MAJOR PROJECT ASSESSEMENT
Gwandalan Residential Subdivision
Proposed by Lakeside Living Pty Ltd
Major Project Application MP 10-0205

Director-General's
 Environmental Assessment Report
 Section 75I of the *Environmental Planning and
 Assessment Act, 1979*

March 2011

Plan of: Proposed Subdivision of Lot 3 DP 588206

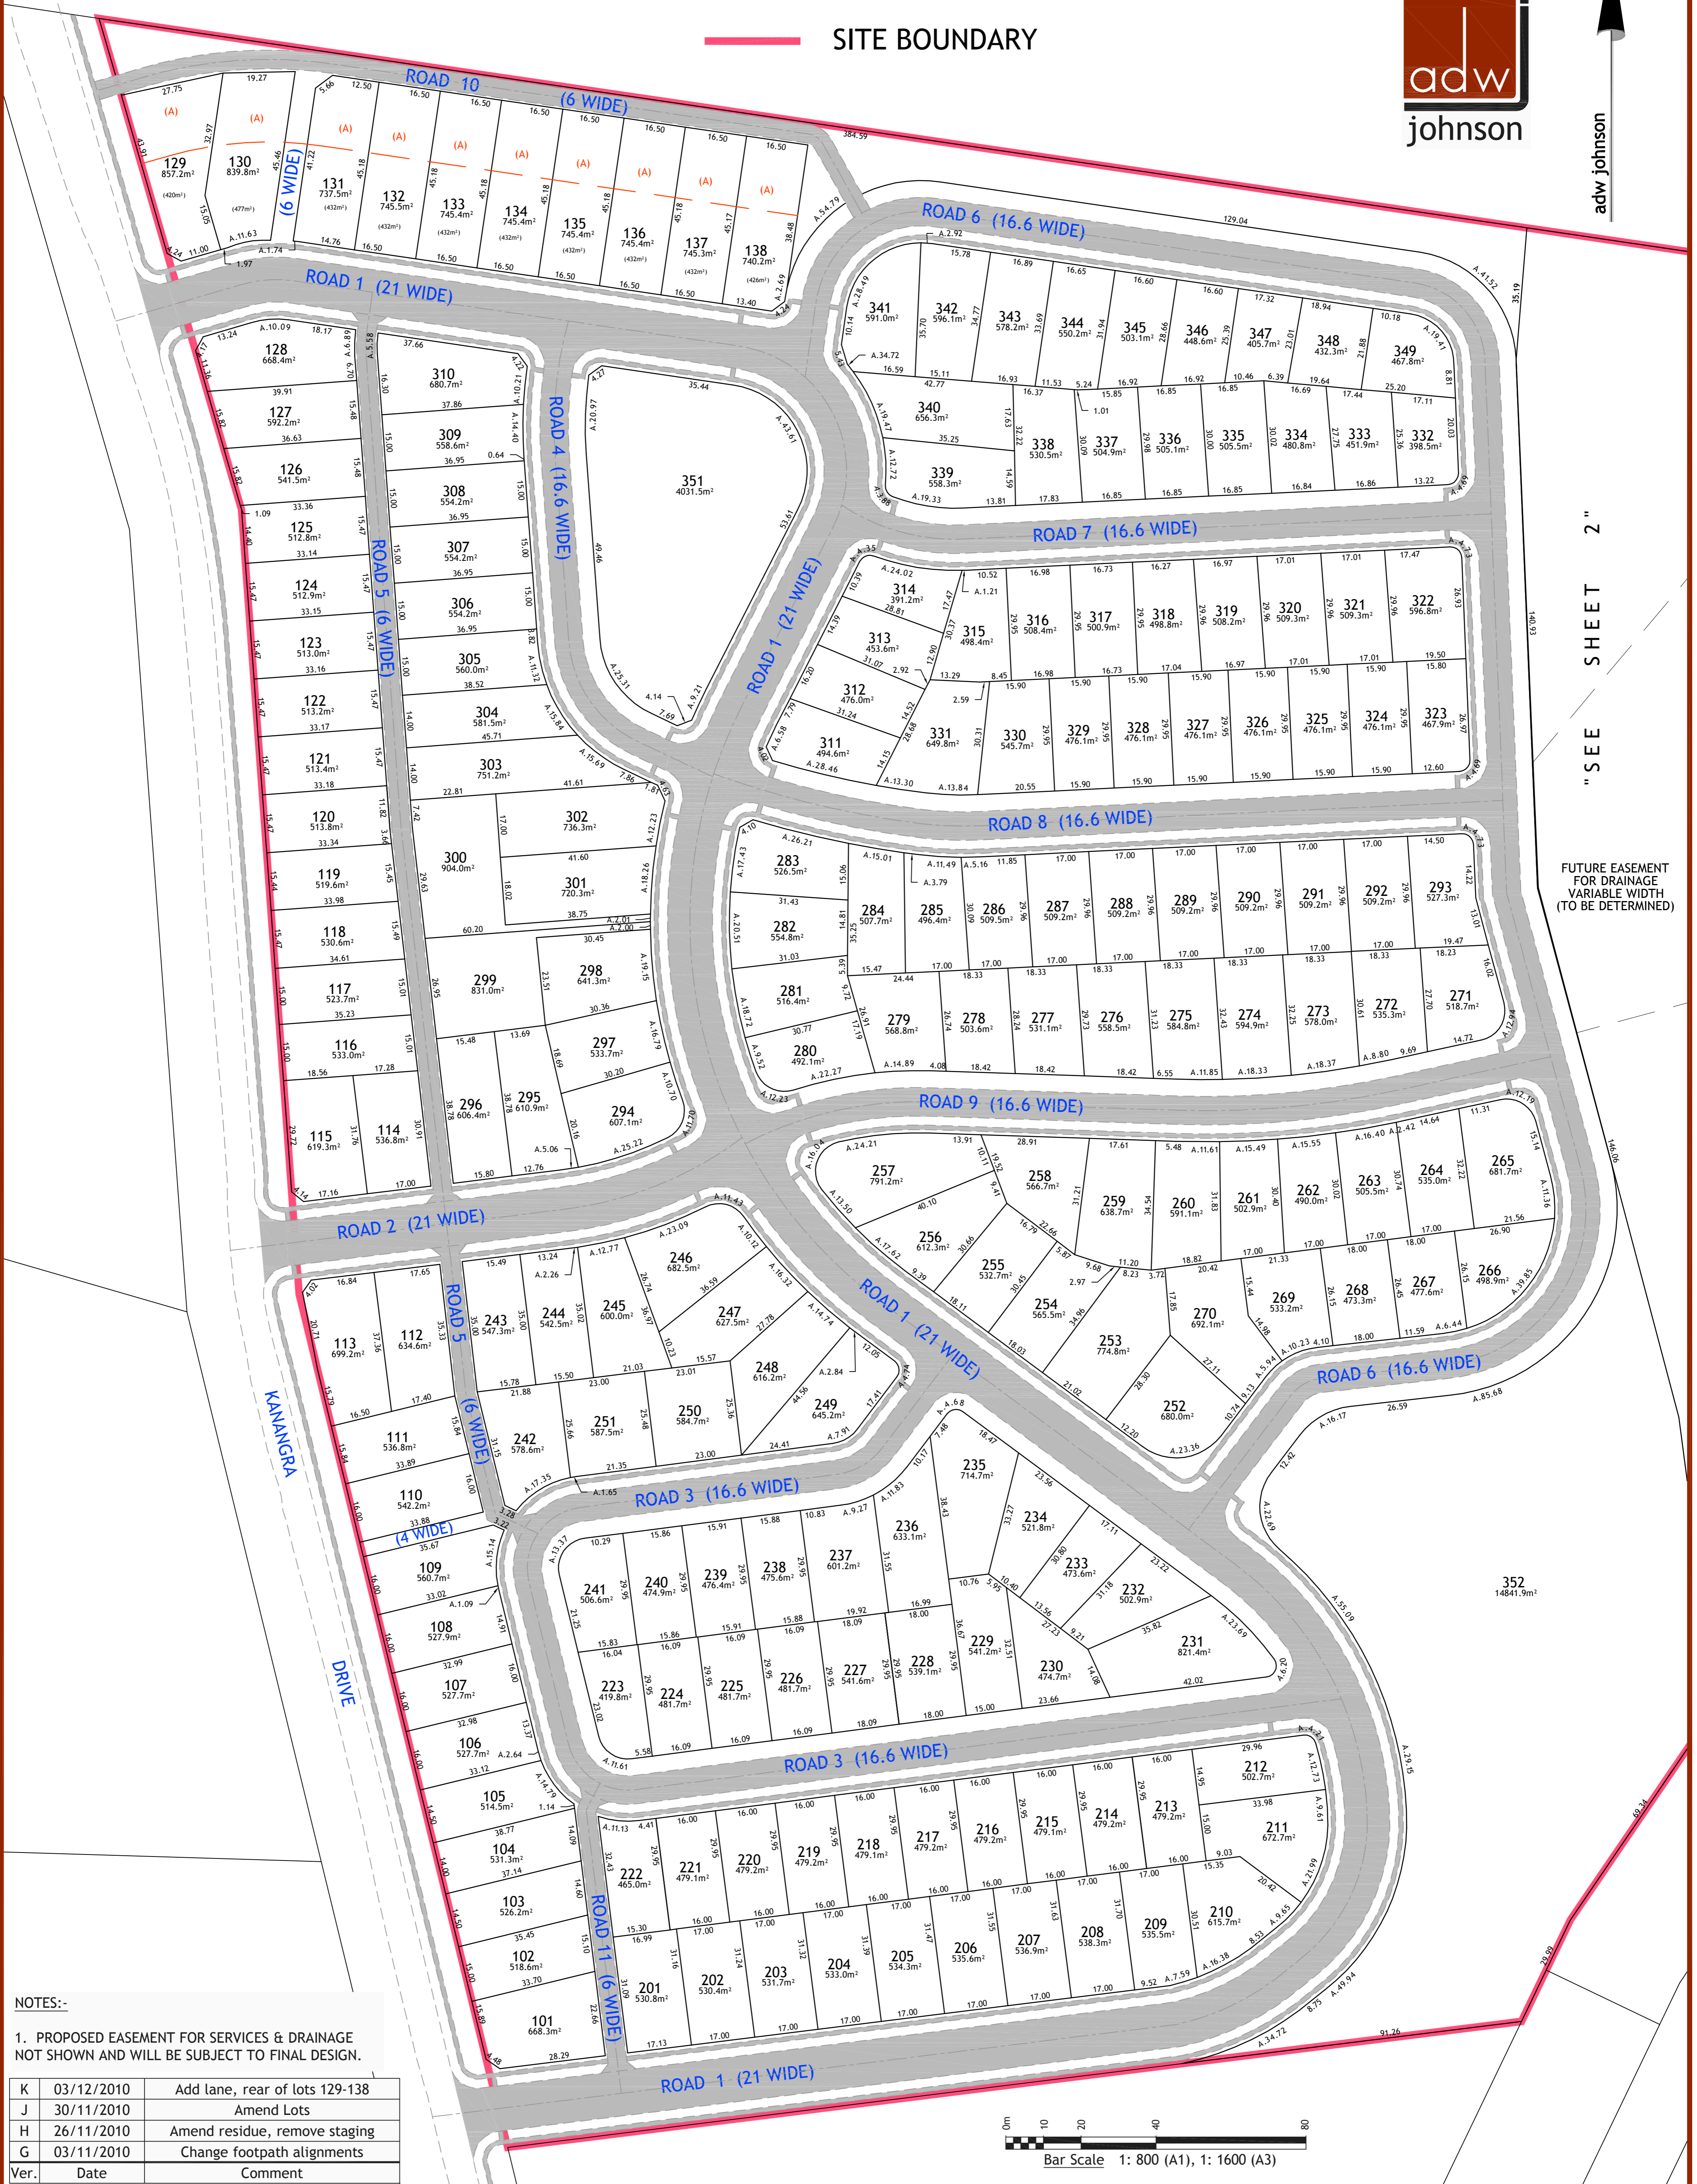
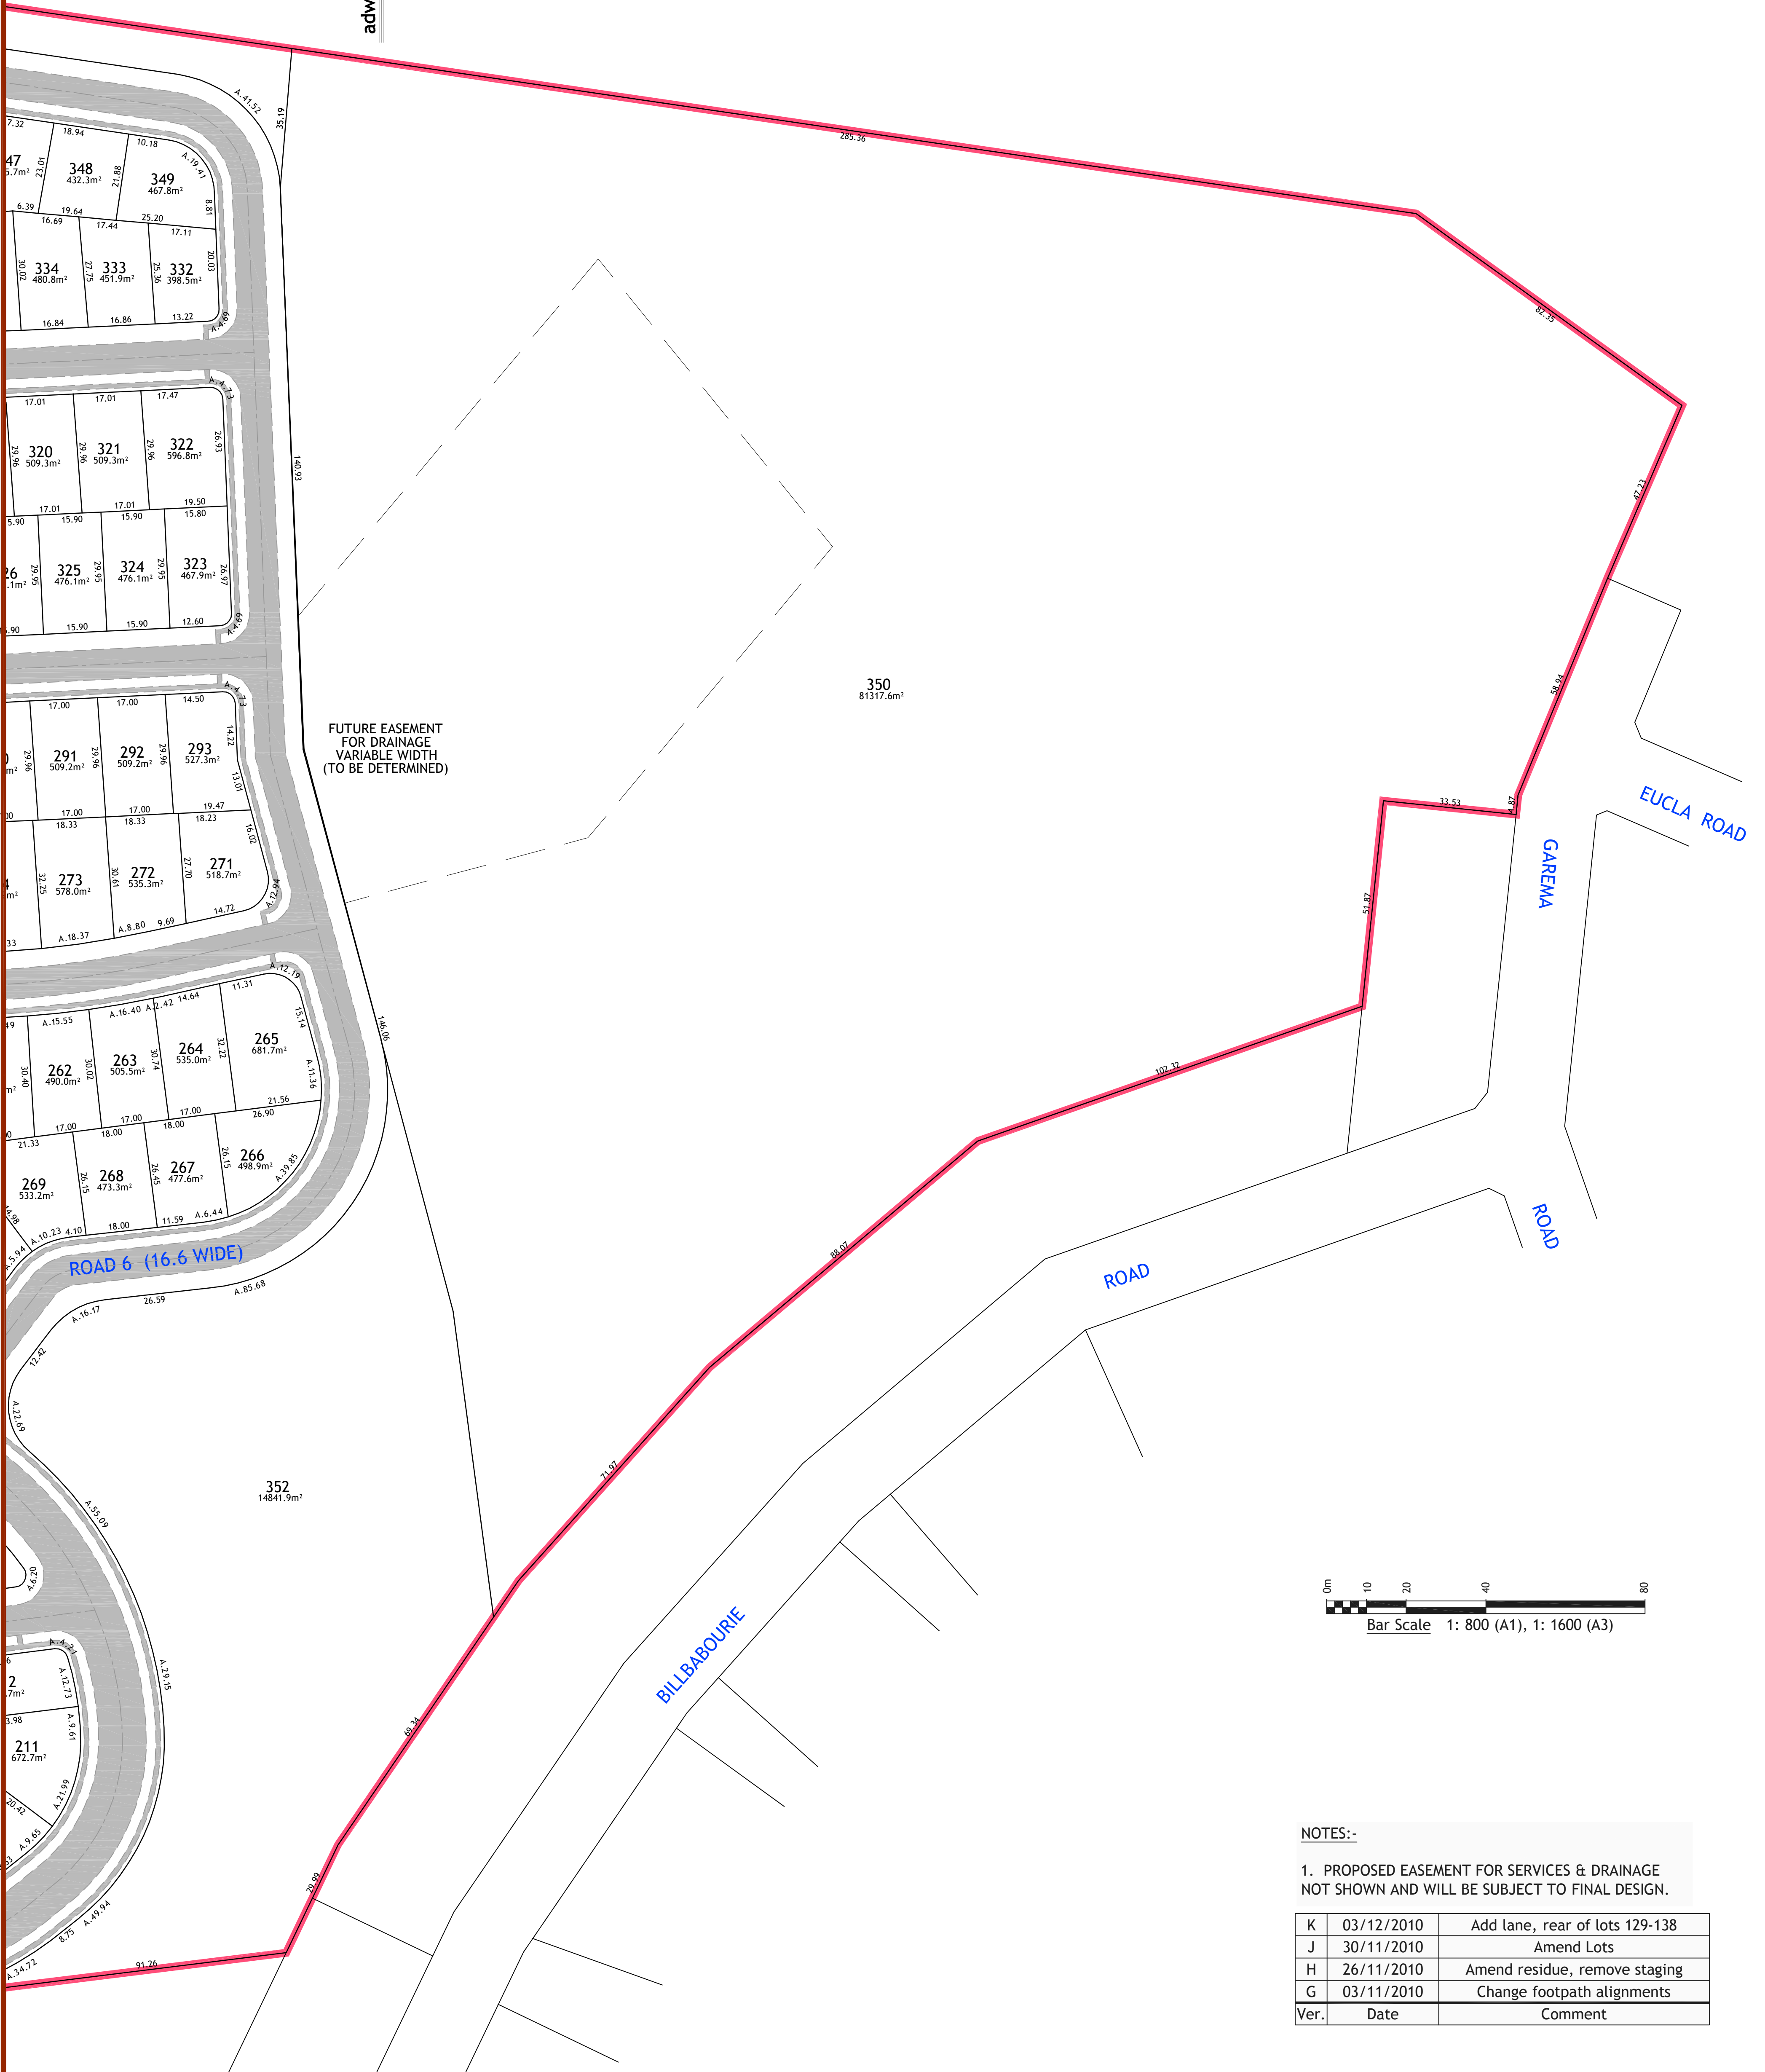
- Increased bushfire APZs for north-west lots (lots 129 to 138) and Road 6 widened from 7.6m to 8m;
- An easement for the stormwater system on the residual lot for management by Council;
- Management plans required to manage and mitigate construction impacts, impacts on flora and fauna, and erosion and sediment control;
- Detailed plans submitted for road works, stormwater and public domain landscaping as the submitted plans do not provide the detailed design;
- Provision of utility services for the servicing of residential lots prior to subdivision certificate;
- Provisions for regional and local contributions.
